RE: SE-24-00010 – Mallula-Dykes Notice of Application
SR 903 milepost 6.45 Rt.

We have reviewed the proposed project and have the following comments.

CONCEPTUAL SITE PLAN

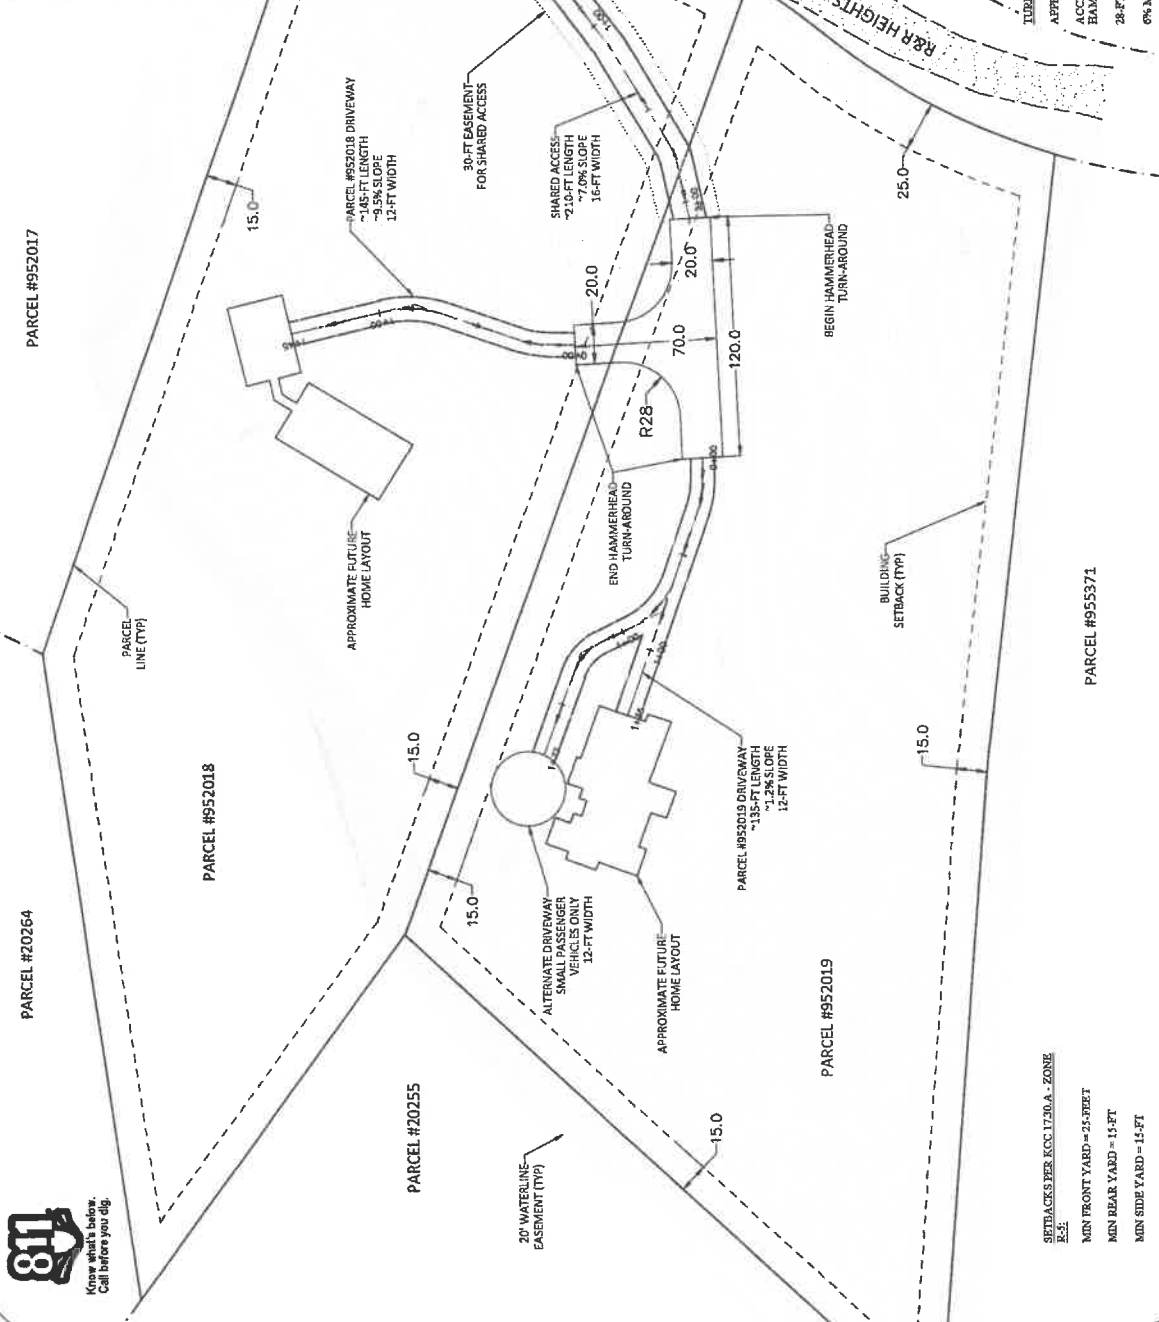
- The subject property is adjacent to State Route 903 (SR 903), a Managed Access Class 4 highway with a posted speed limit of 45 miles per hour. The existing joint-use access (Mountain Ridge Road) at milepost 6.45 right was approved on October 10th, 2008 (Access Connection Permit 3594 - SR-903). This permit included the subject properties. The county should be aware, any future subdivisions proposing to use Mountain Ridge Road will require the permit to be updated.
- The stop sign located on the northeast corner of SR 903 and Mountain Ridge Road does not meet MUTCD minimum requirements. Further, the intersection does not have a stop bar installed. We recommend the county require the applicant to update the stop sign and install a stop bar in accordance with current MUTCD standards.
